Subject: RE: Attached letter from Kirklees Council regarding application number 2023/90773 at location Land at, Penistone Road, Fenay Bridge, Huddersfield, HD8 0AW
Date: 22 March 2023 17:42:51

I would like to advise that structures conditions (8 & 9) can not be discharged subject to the satisfactory resolution of the following requirement:

Title: External Works

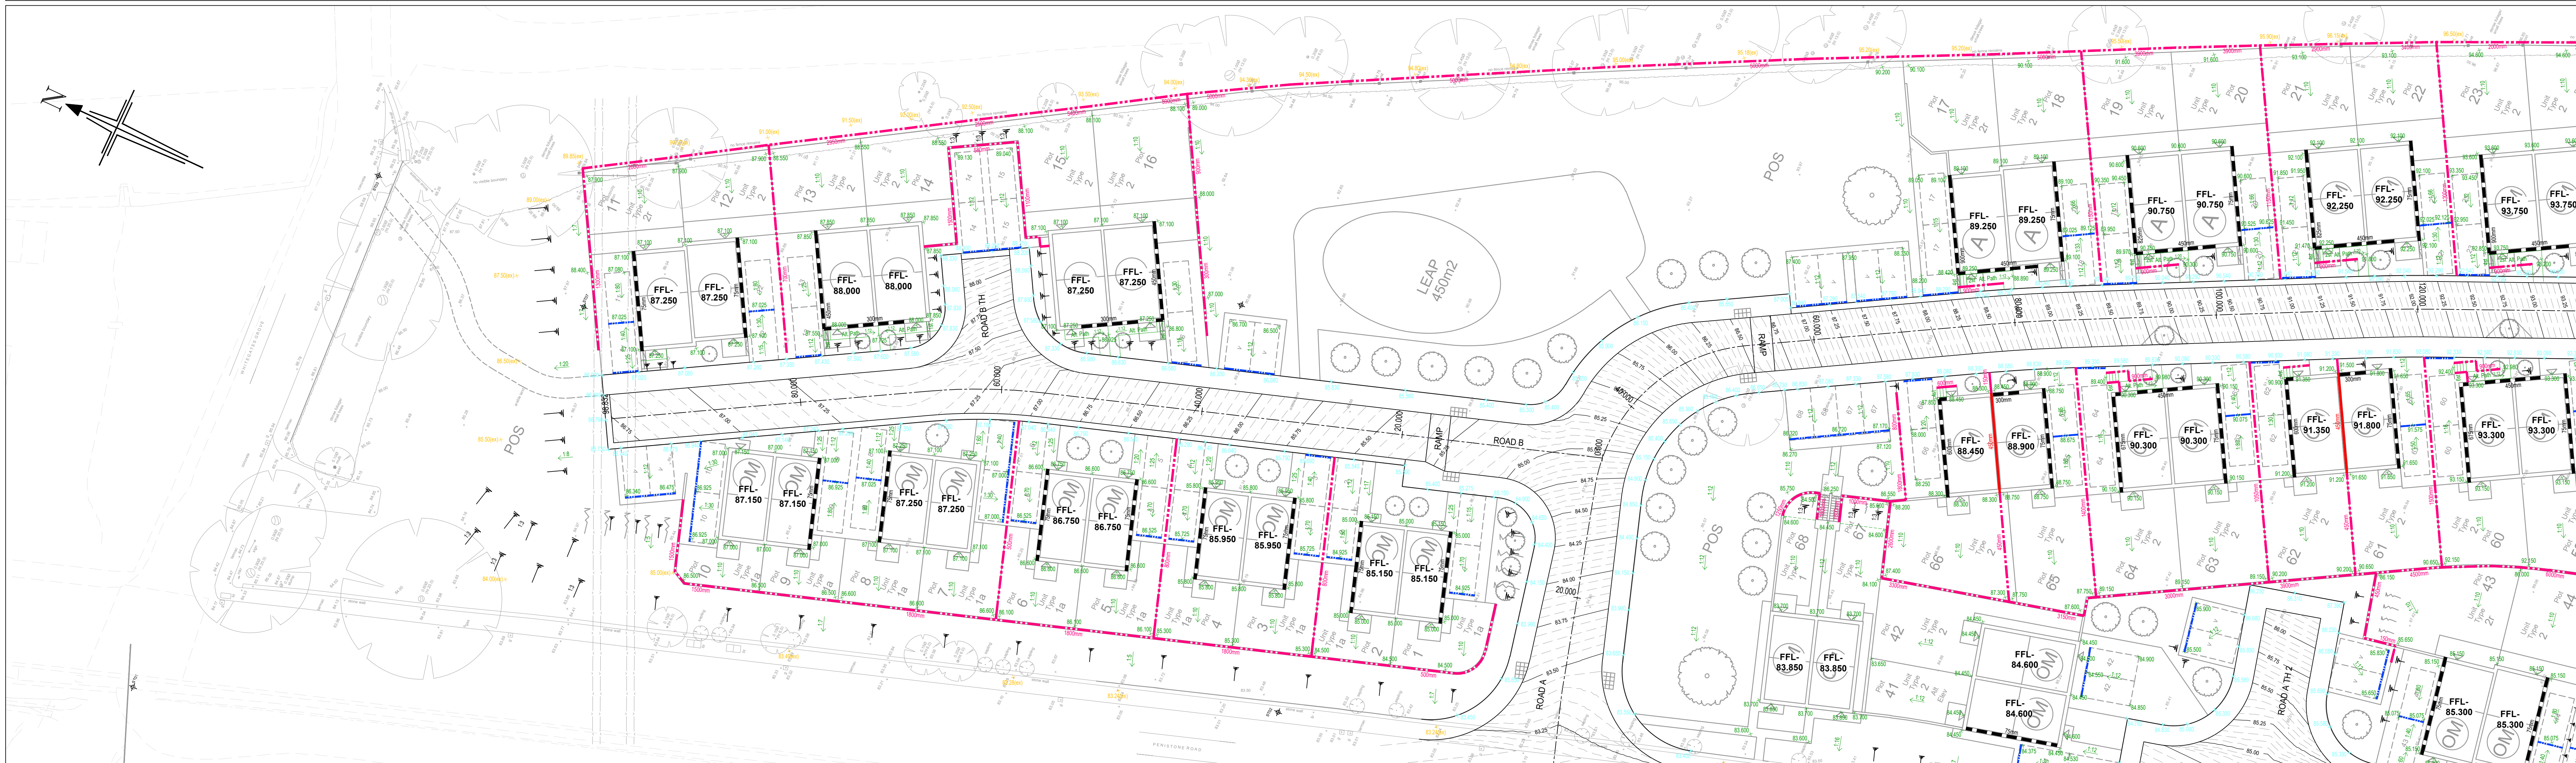
1. Condition 8 – This will require the formal technical approval (via the submission of AIPs) for the design of all proposed retaining walls adjacent to the new highway including any modification to the existing highway retaining wall supporting the A629 Penistone Road, as stated in <https://www.kirklees.gov.uk/beta/regeneration-and-development/pdf/highways-structural-procedures.pdf>.
2. Condition 9 – This will require the submission of detailed and fully dimensioned X-sectional details so as to determine whether the design of proposed culvert headwalls on the A629 Penistone will be liable to a formal technical approval, as stated in (1) above. In addition, the design of all oversize PCC manholes (ID> 900mm) will be liable to approval via certification, as stated in <https://www.kirklees.gov.uk/beta/regeneration-and-development/pdf/highways-structural-procedures.pdf>.
